Re: Permit No. 2207-019 SUB2 - Strand Residence - 6950 SE Maker St. - Additional Input and Feedback

We have reviewed the SUB2 documents that are on file as of 3/1/2023 and that pertain to review comments from Community Planning and Development. The proposed project (6950) does not meet the definitions of - and therefore - the requirements of the Mercer Island City Code (MICC) with respect to applicant's determination of existing grade and downhill facade height requirements.

INDEXING INFORMATION

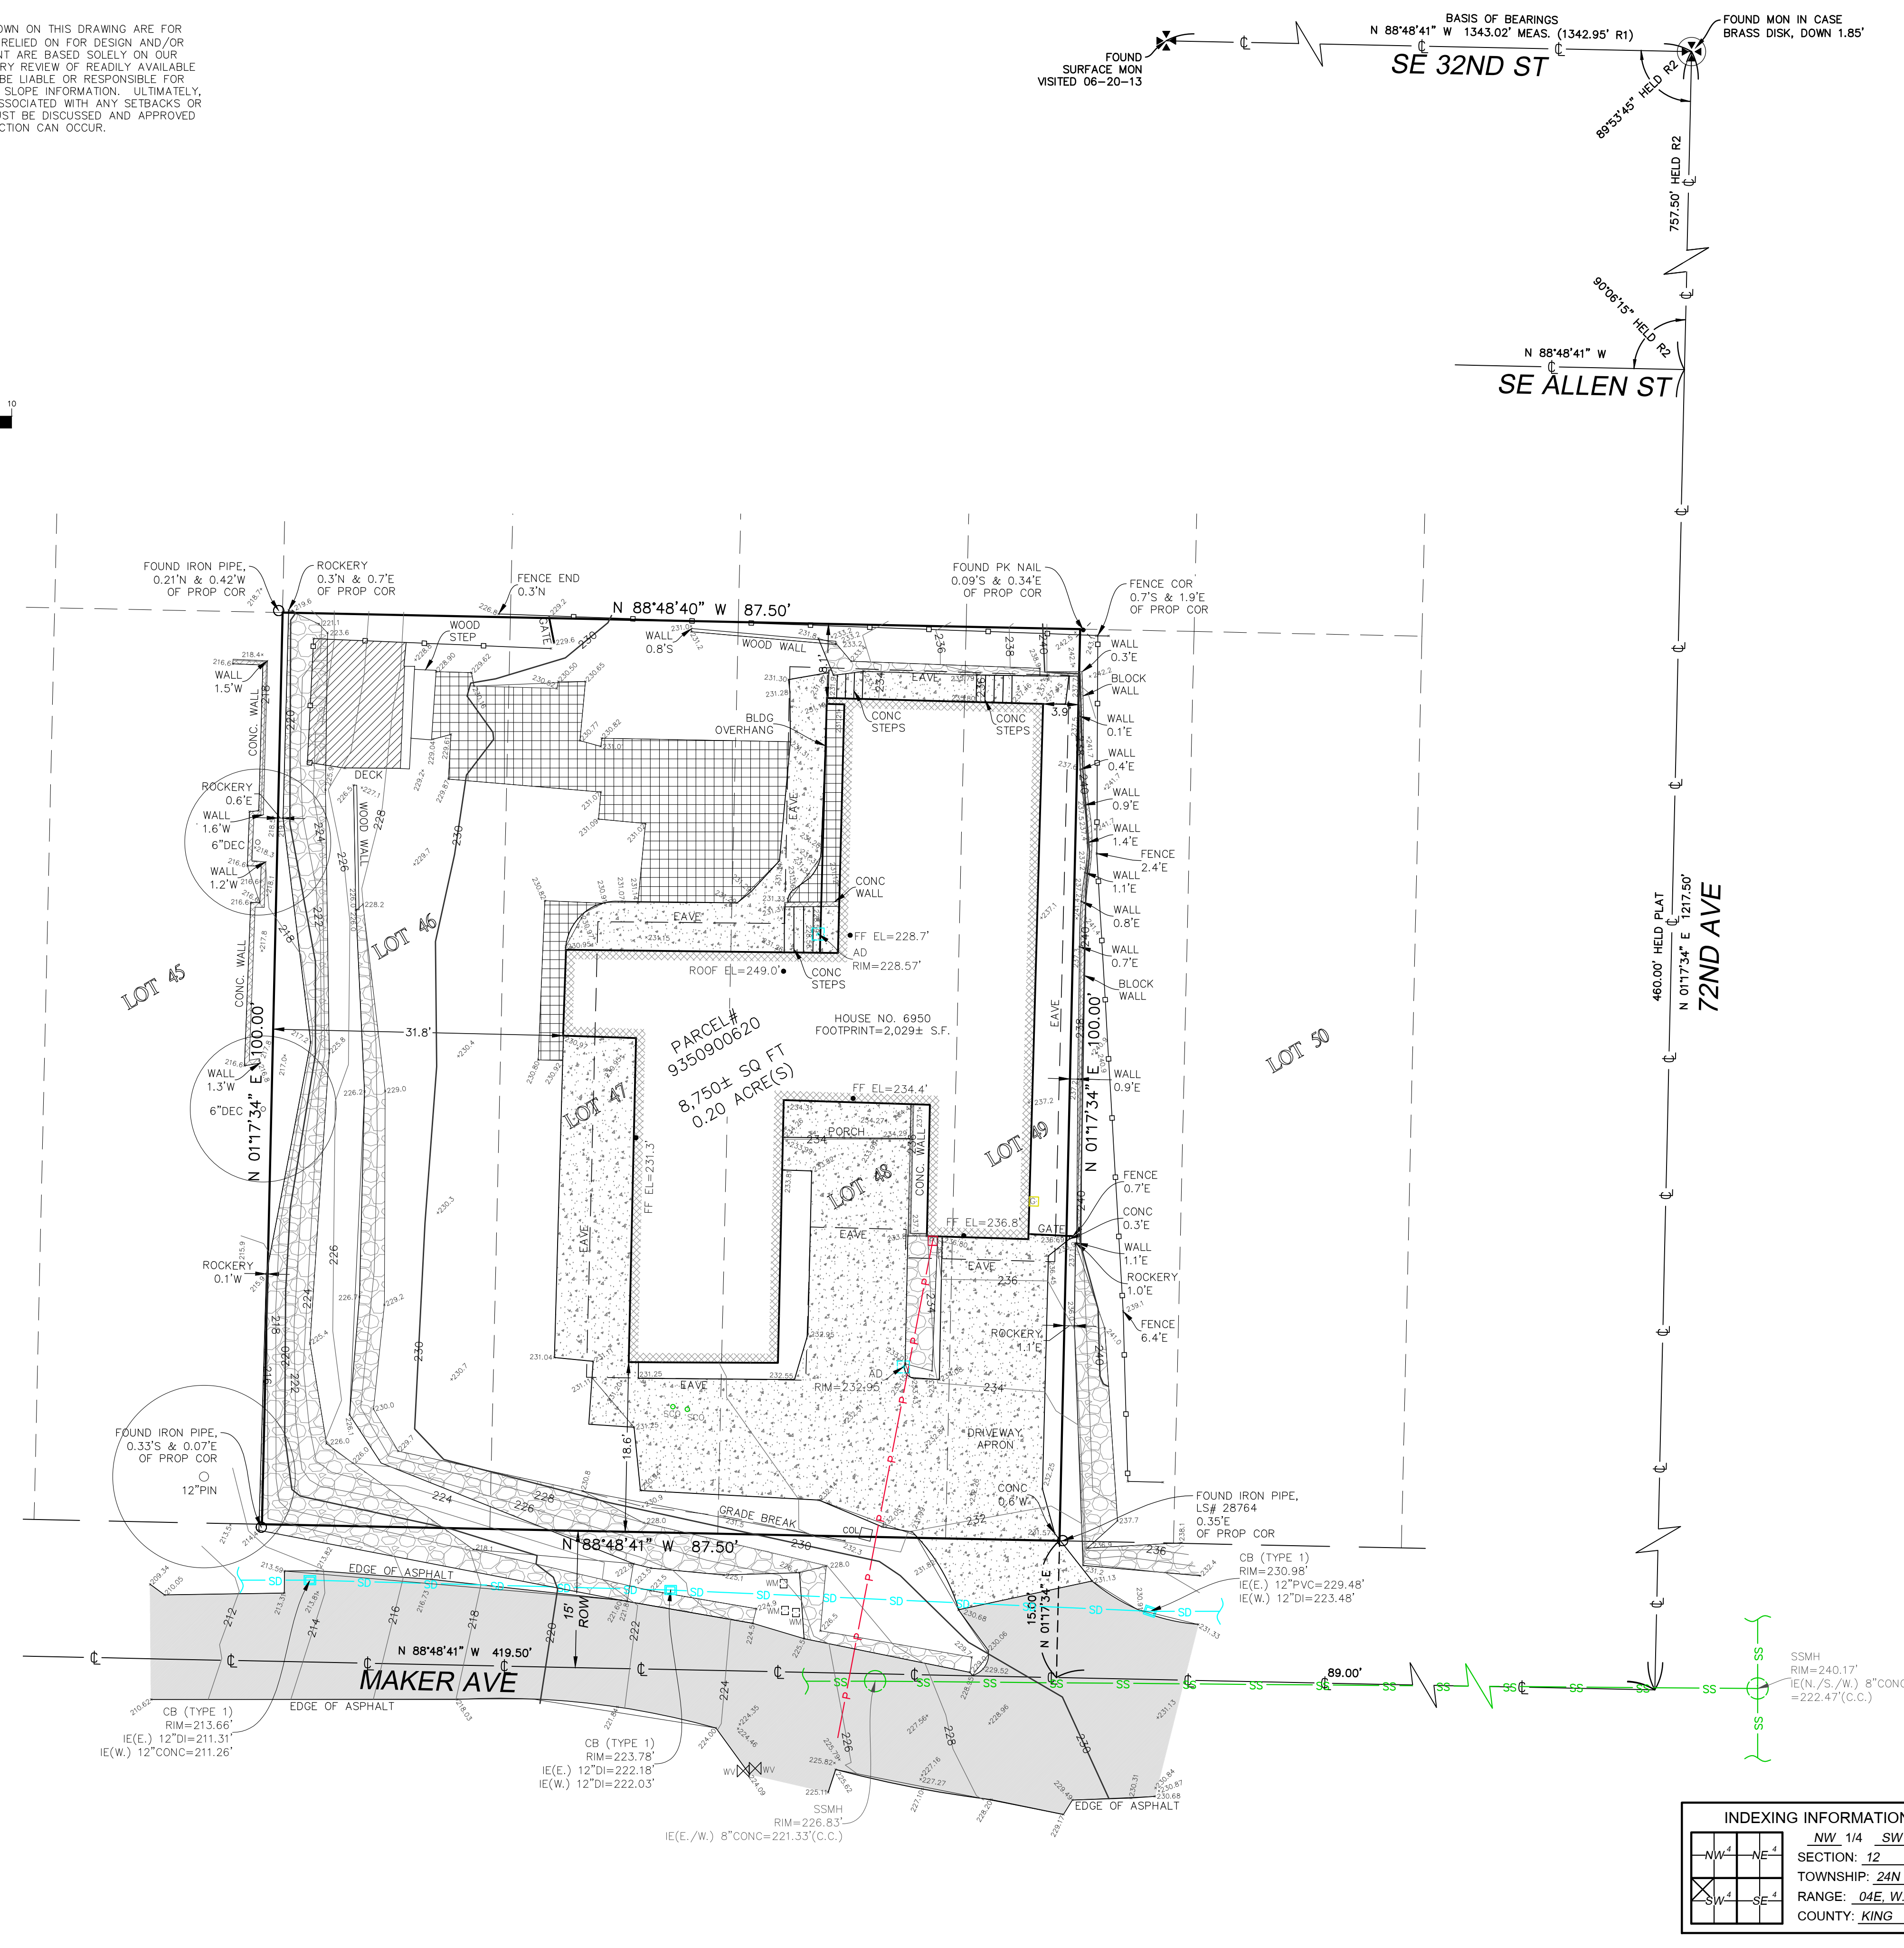
We object to the existing grade for the 6950 site being designated as "the surveyed grade prior to start of this proposed project (5/27/2021)" as stated in the applicant's Comment Response in reference to Terrane survey sheet 1 of 1.

This site was significantly "altered" prior to development of the existing home with extensive placement of fill materials which were retained with tall rockeries. This is well documented in the October 2022 public comments and the geotechnical engineer's initial report.

Our evidence is substantial and verifiable that the Terrane survey (5/27/21) does not represent or meet the MICC definition of existing grade, and as such, the City should use its Administrative Interpretations (#DCI12-004 and #0404) to determine existing grades prior to alteration for GFA and ABE calculations.
